ROLLING MEADOWS CHANNEL & FLOODPLAIN MODIFICATION

EPC STORMWATER REVIEW COMMENTS
IN ORANGE BOXES WITH BLACK TEXT

PCD-ENGINEERING REVIEW COMMENTS
IN BLUE BOXES WITH BLUE TEXT

60% DESIGN PLANS
JANUARY 2023

| OVERALL DRAINAGE PLAN - LOWER REACH | | | |

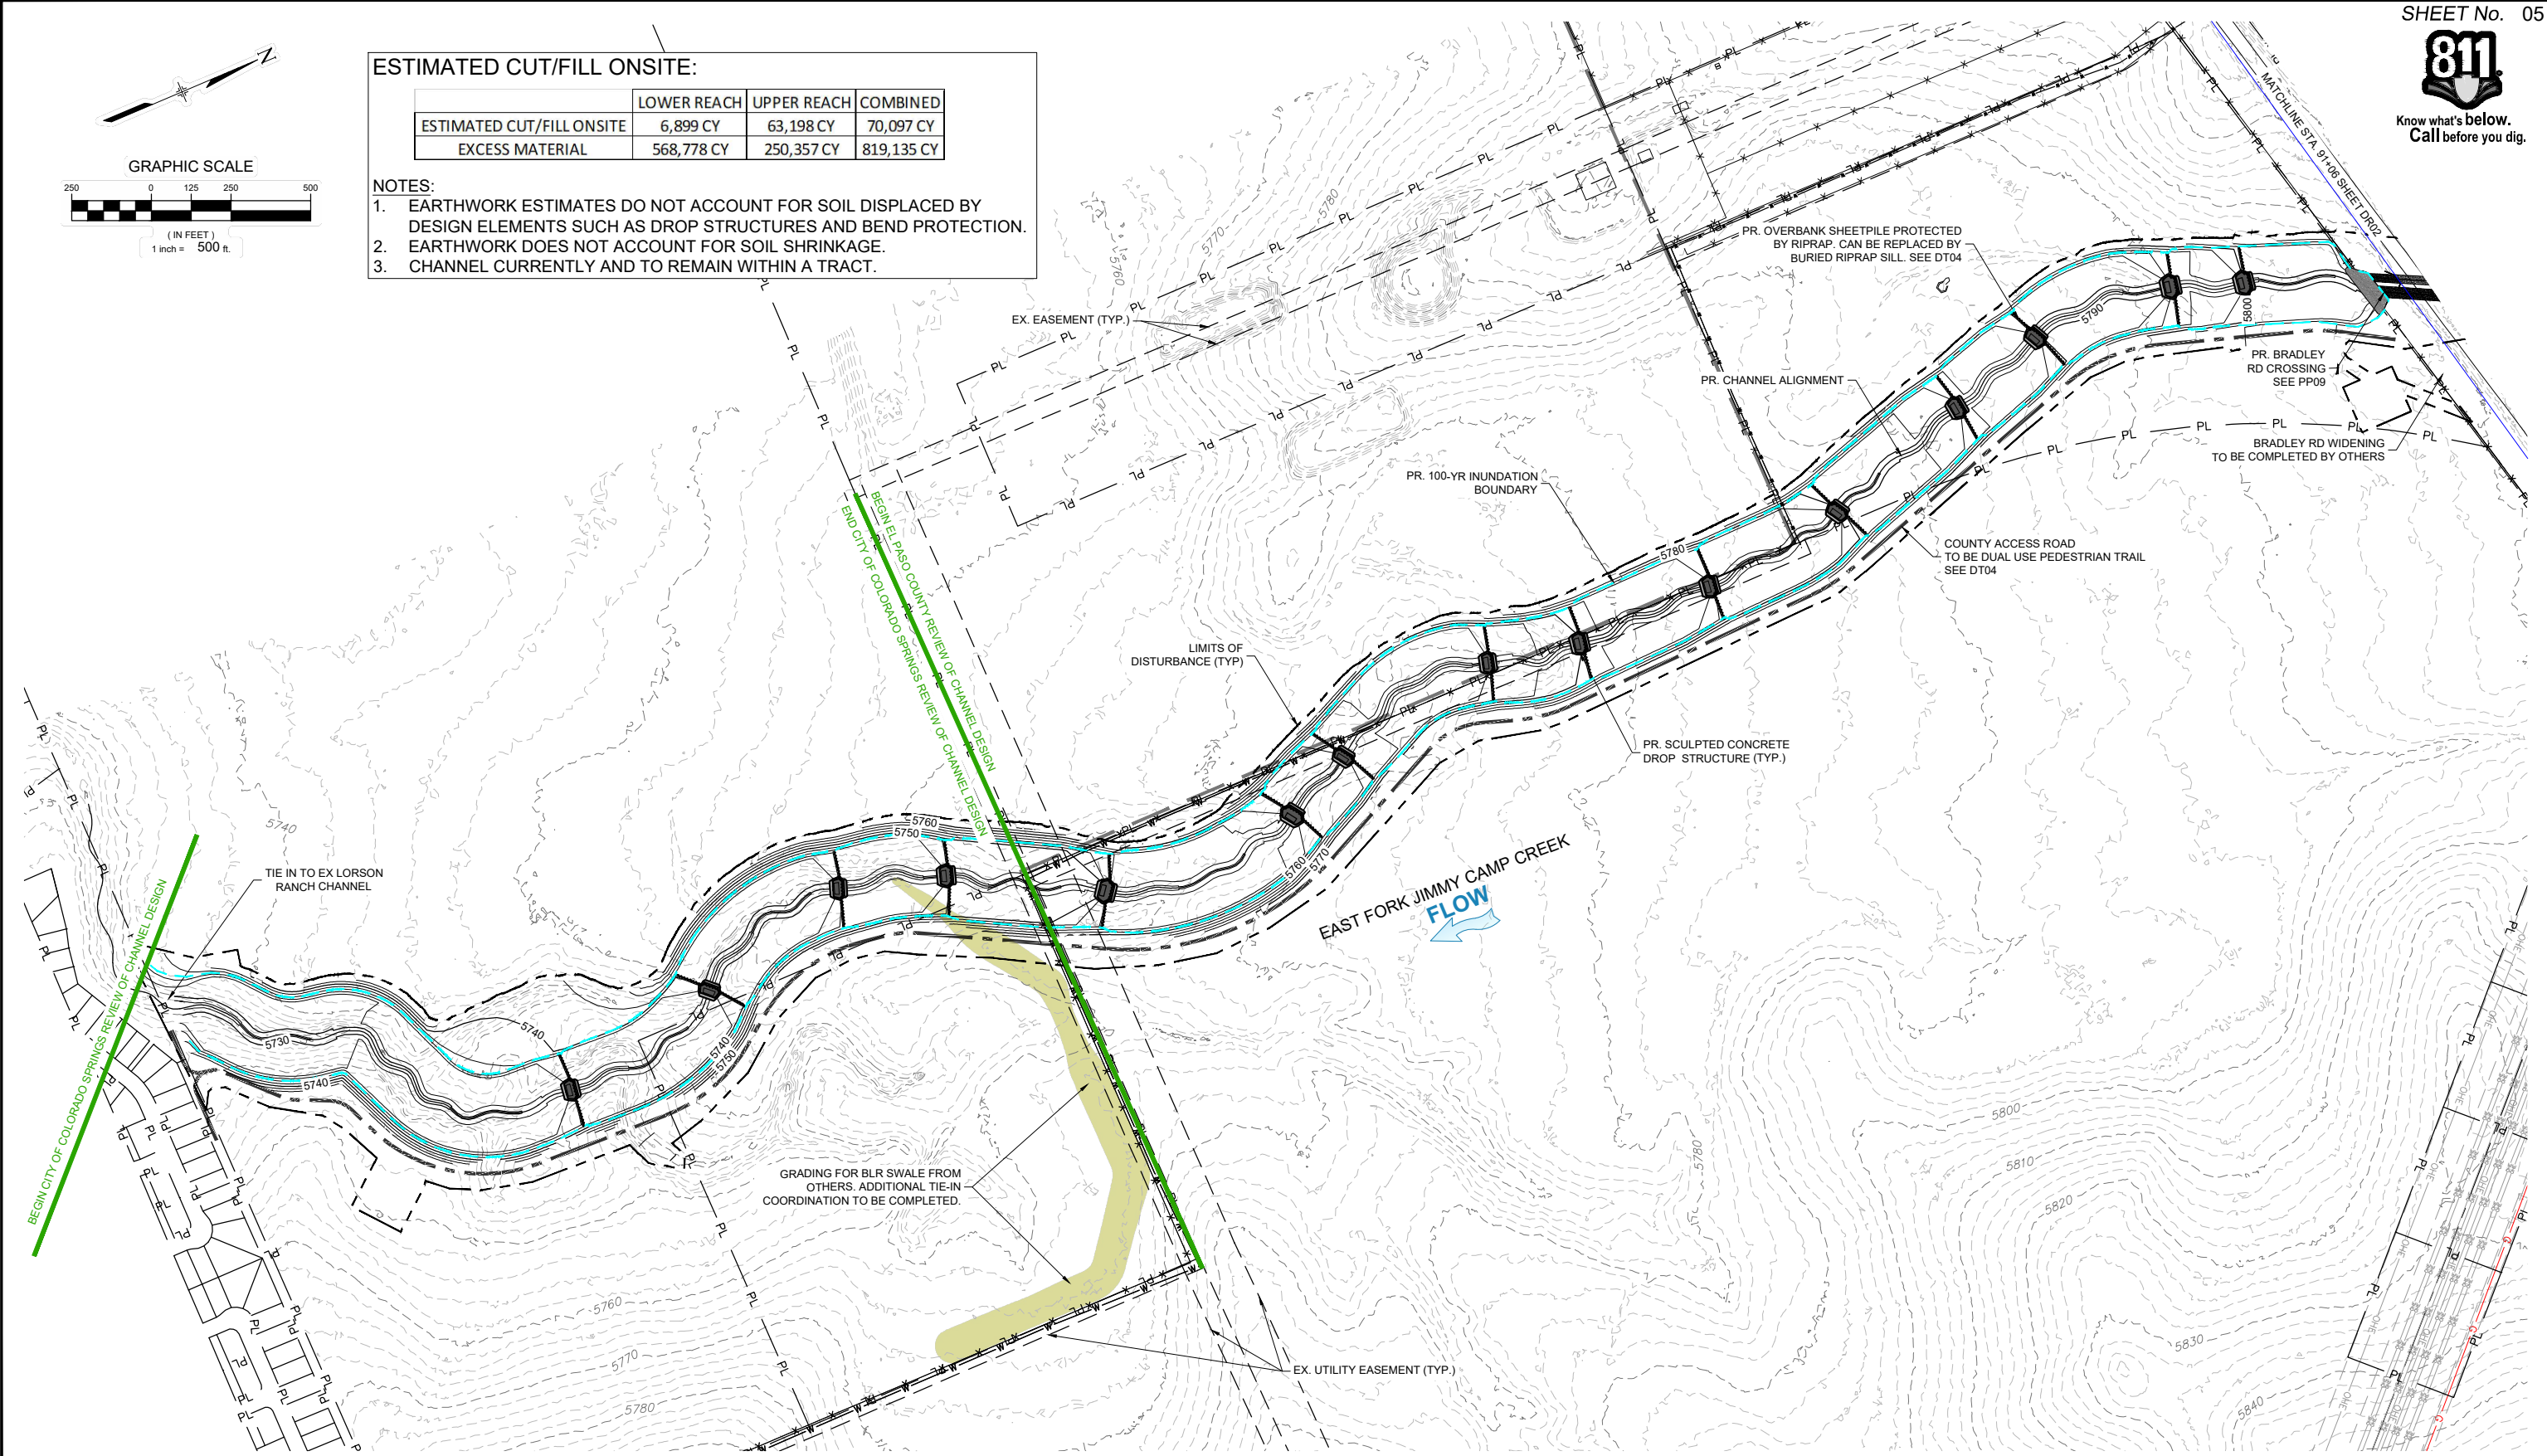
Indicate if channel will be within a tract, easement, etc

Label all easements

smooth out edge?

| HORIZONTAL CONTROL PLAN - LOWER REACH | | | |

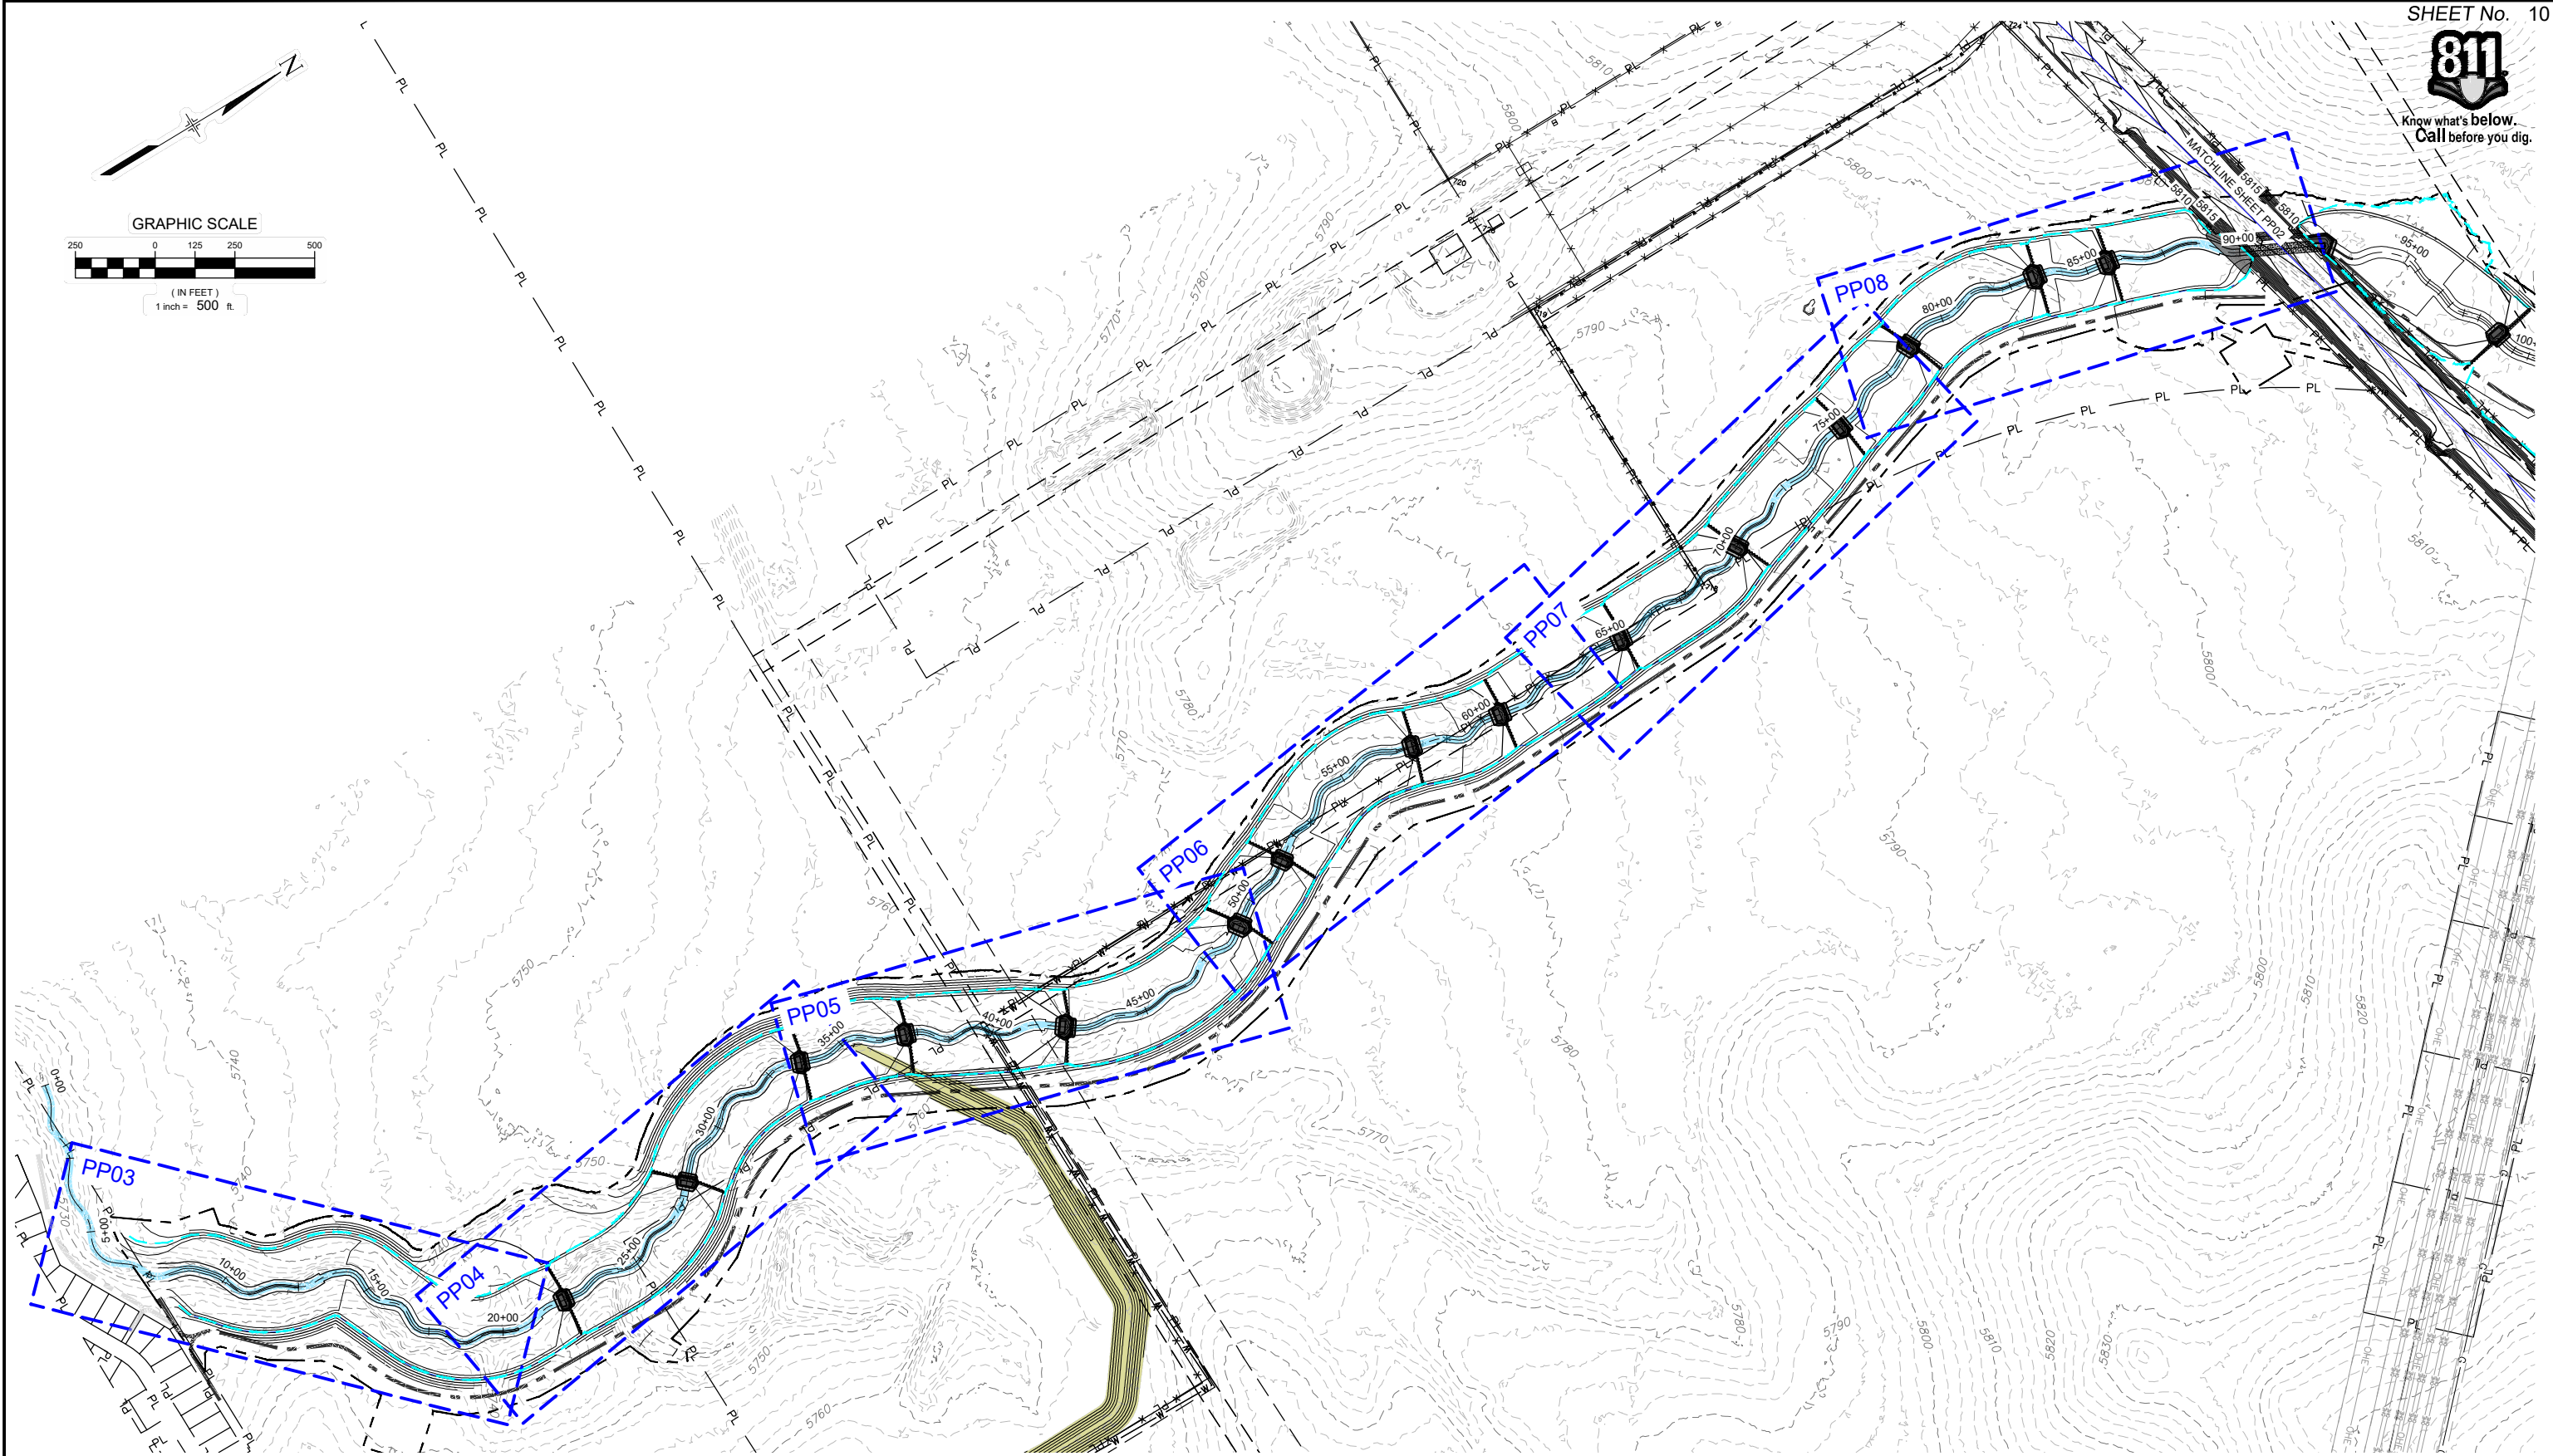
Alignment table or centerline labels will need to be added on this sheet or on the plan & profile sheets
